Subject: FW: AB/63/20/DOC 74-76 Canada Road, Arundel, West Sussex BN18 9HY - Planning Condition 8

From: Pendry, Glenn [REDACTED]
Sent: 17 September 2020 07:22
To: Anita Gardner <Anita.Gardner@arun.gov.uk>
Cc: 'Lynnette St quintin' [REDACTED]
Subject: AB/63/20/DOC 74-76 Canada Road, Arundel, West Sussex BN18 9HY - Planning Conditions 4 & 8

Condition 4 – Construction Plant and Materials

Condition 8 - Access

- Indicates Site Cabin - Oasis Unit Location
- Indicates Proposed Materials offloading Area to Storage Area/s.
- Indicates Proposed Materials Storage Area
- Indicates Proposed Contractor Parking Provision (on-street)

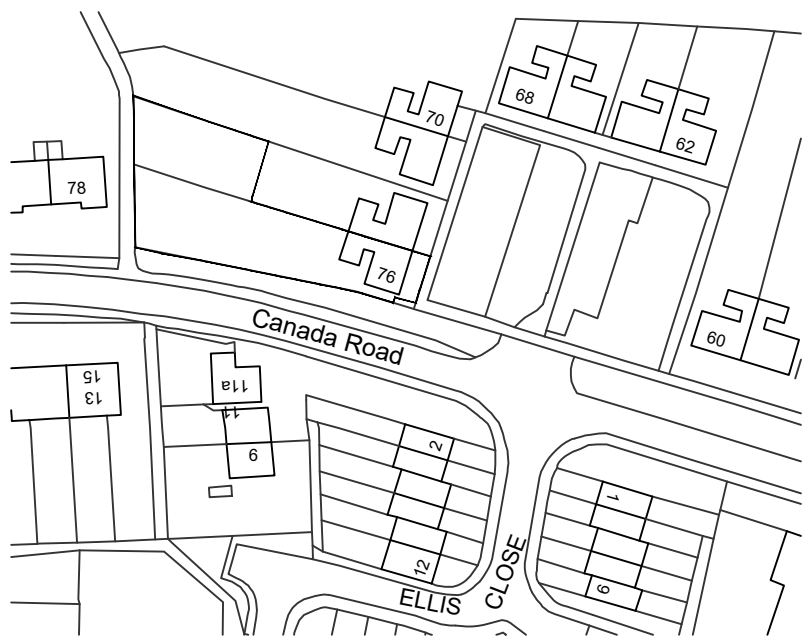
As per, and adding to Stephens comments 30th July WSCC. Parking by contractors can naturally take place on street while taking into consideration any existing traffic regulation orders. However it is not advised that a specific area for this is marked on discharge of condition plan. This is because the roads status as public highway is secured by statute and thus should be free for use by all. It would also restrict contractors to only parking in those specific locations when they may not be free.

This could be mitigated by way of a temporary traffic regulation order, but the applicant does not seem to be proposing this.

It would be better if a statement was made similar to "Due to the constraints of the site contractors will be required to park on street in a safe and considerate location. Any such parking must take into consideration any existing traffic regulation orders.

Similarly with materials storage, typically we try and avoid this if possible but it can be permitted with the appropriate licence agreement from WSCC Highways. Please can the applicant confirm if they do wish to store materials on the highway and I will enquire with the area office if 'in principle' such a licence would be forthcoming in such a location.

SWEPT PATH ANALYSIS WITH 6.4m CROSSOVER
(1:100)

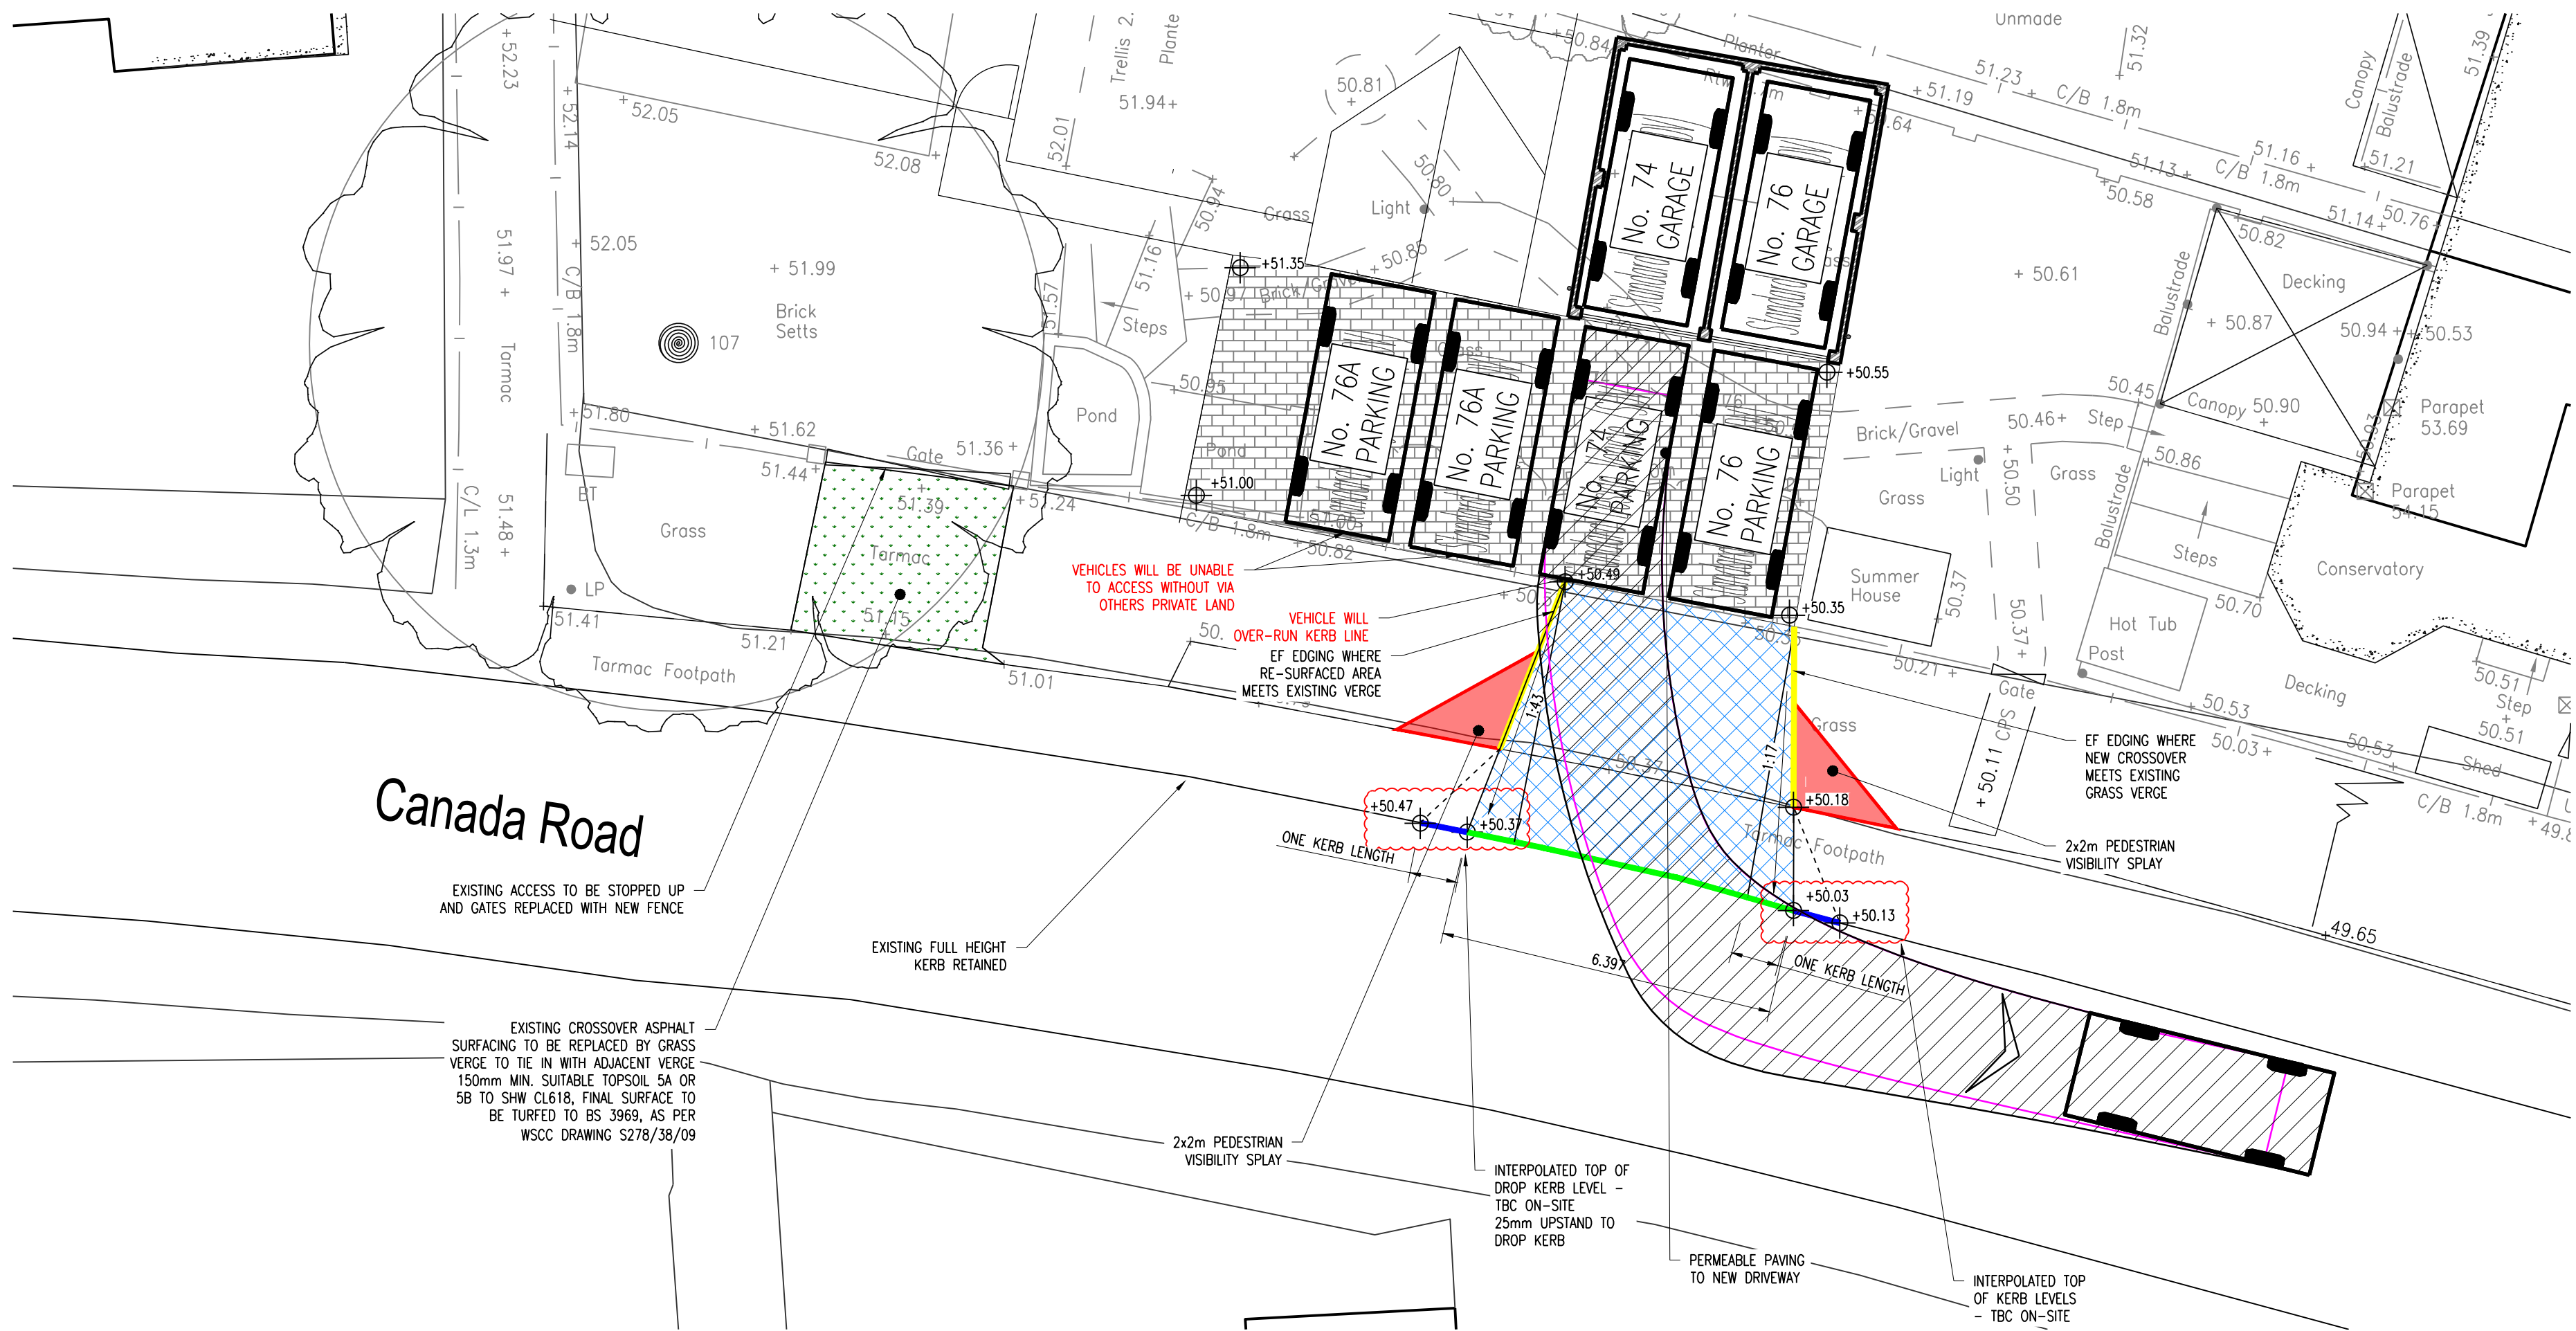
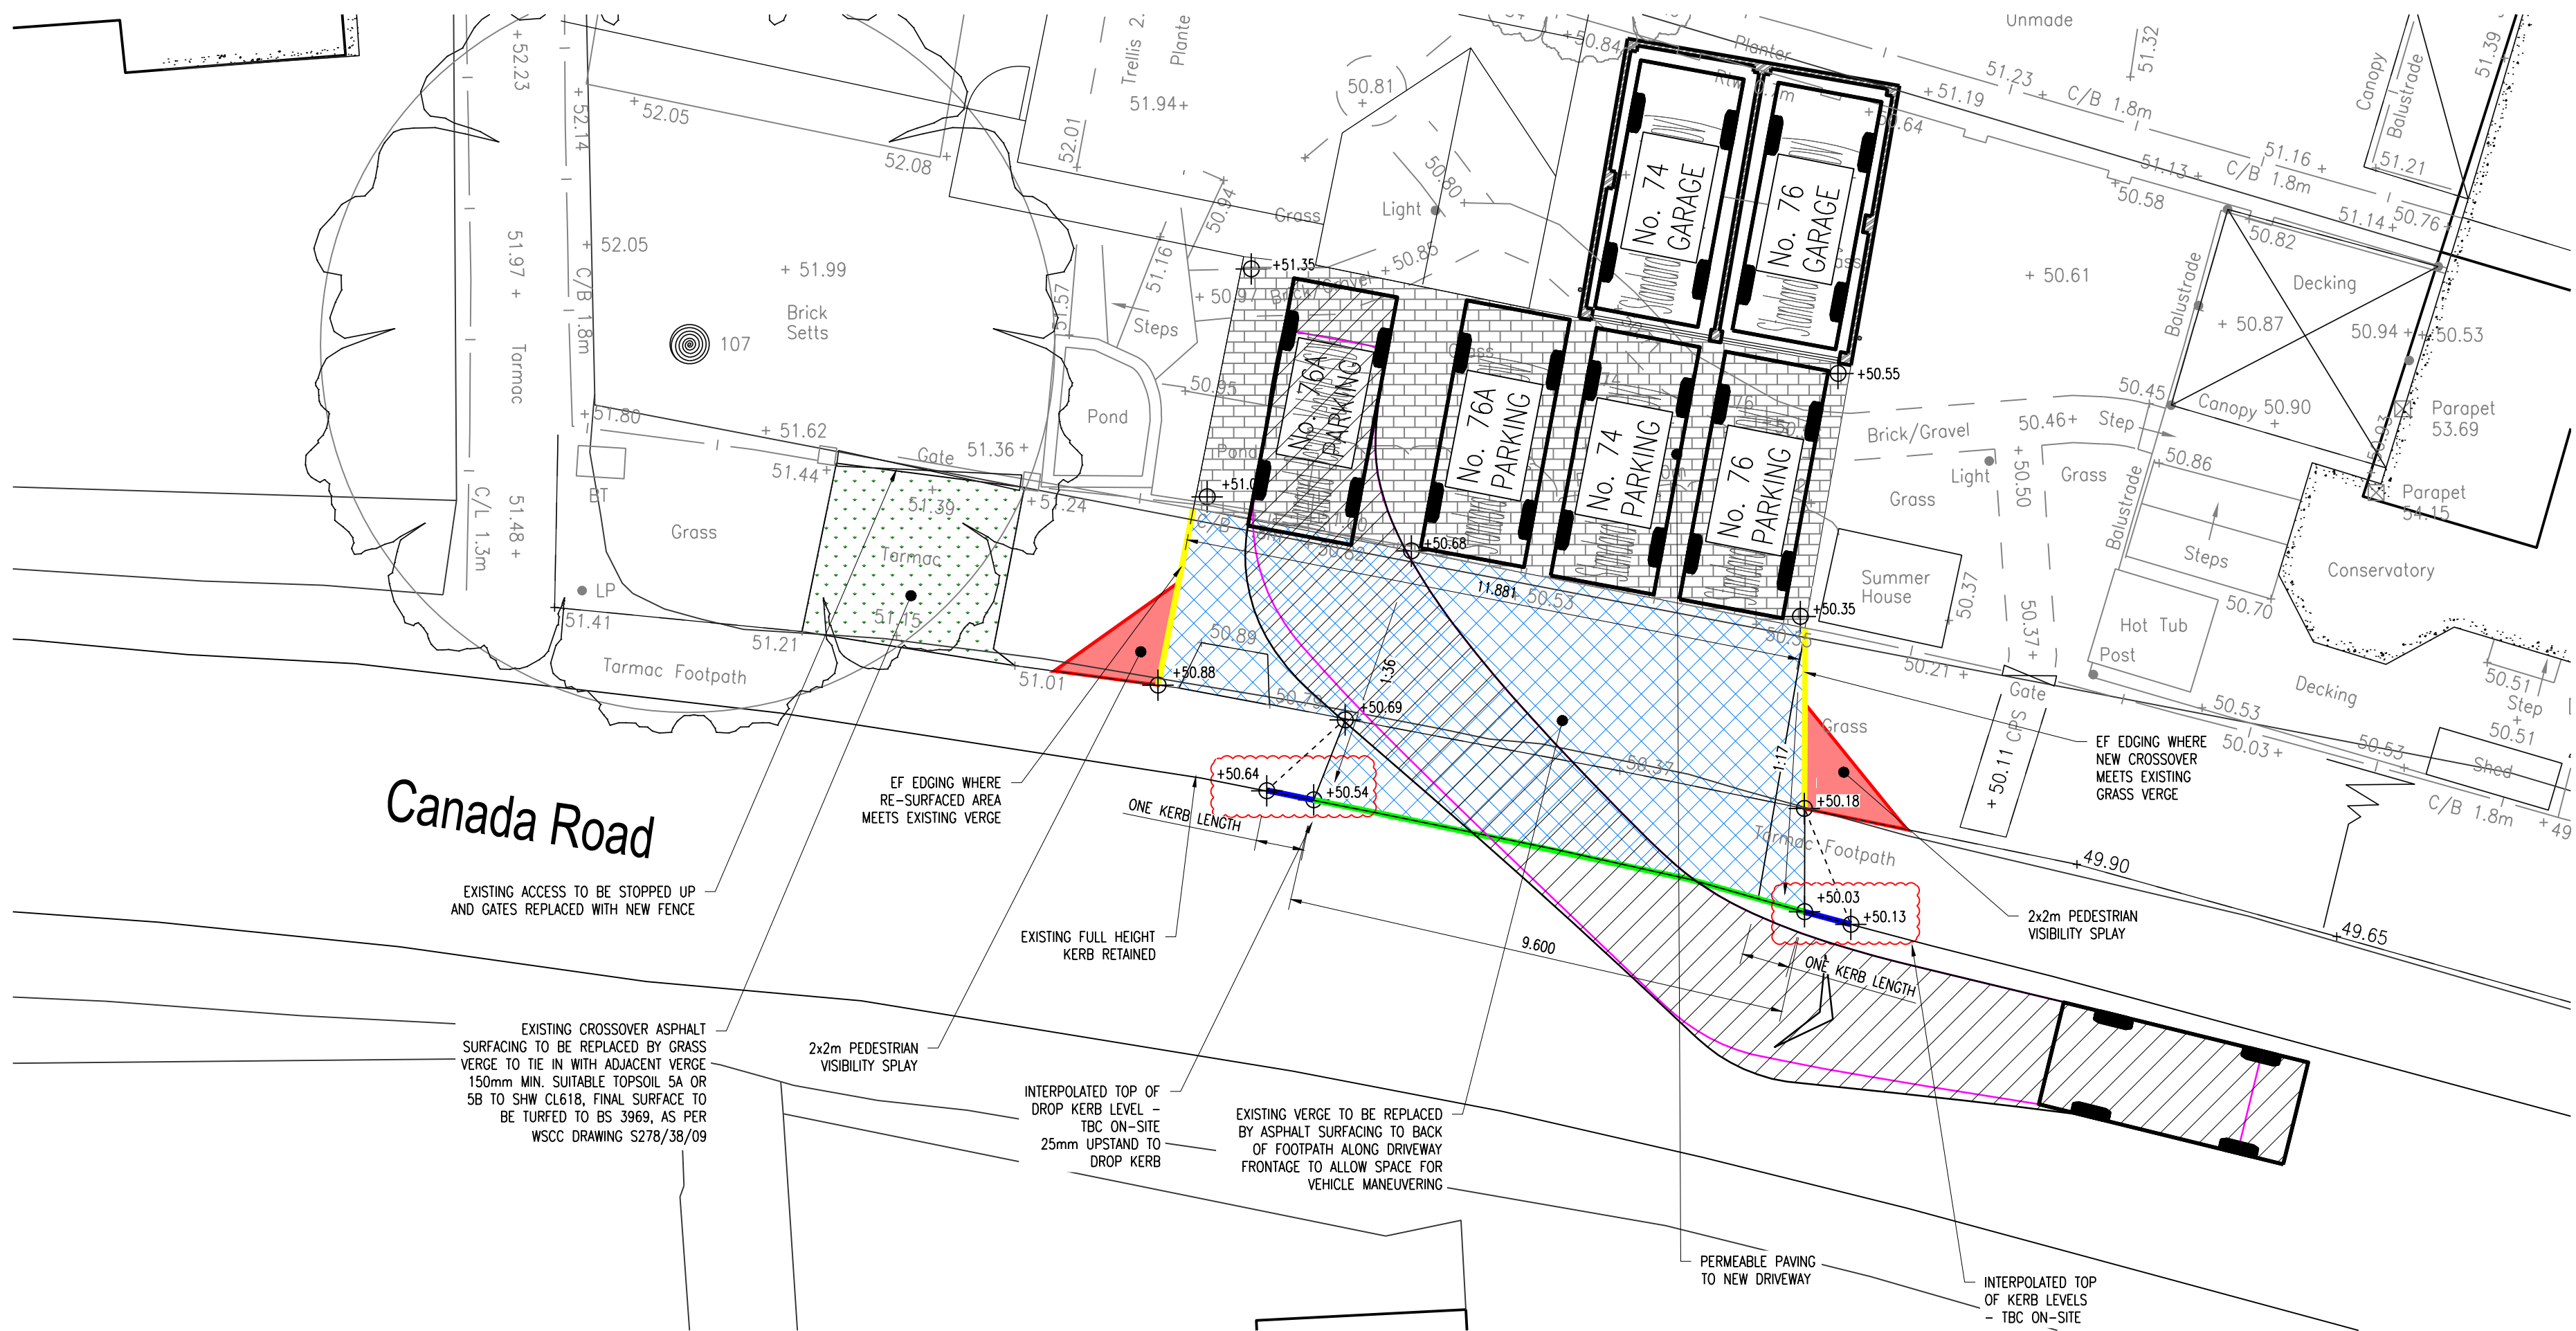
Am I right in thinking they have not submitted any plans that show a reduced width crossover at 6.4m wide? I can't see such plans on the Arun Planning Portal or on the email string. The latest seems to be Plan 101A as attached to one of Glenns emails.

Glenn seems to be asking if a crossover width of 9.6 metres would be acceptable. I can see the logic behind this as it would allow for convenient access to the garage spaces and hardstanding for 74 and 76 Canada Road and allow for access to the proposed parking spaces for the new dwelling. To my mind a 6.4m wide crossover may limit accessibility for some of the spaces, though its difficult to say this with any certainty as that has not been demonstrated to date.

Our area office are resistant in granting licence application greater than 6.4 metres in width due to the loss of on street car parking provision. I think the only way forward is to present to the area office a plan that shows how a 6.4m wide crossover is not workable. I.e. showing a 6.4 crossover where it is then clear that vehicles accessing the new parking spaces will be required to bump the kerb in order to access the approved parking spaces. A similar plan showing a 9.6 metre wide crossover or greater can then be provided to show the minimum width required to provide a workable solution. This will then be materially different to what we have presented to the area office with to date to provide us a view on.

Following on from our exchange of e-mails below yesterday, please find attached a copy of the updated crossover proposals in relation to Condition 8 -- Access for your consideration/approval.

In this regard and for the reasons that the off street parking will serve 3 separate properties, namely 74, 76 and 76a and therefore access to each needs to be maintained in its own right (as you will note from the attached), as a result the minimum width we can reduce said crossover to is 9.6m which I hope will be acceptable?
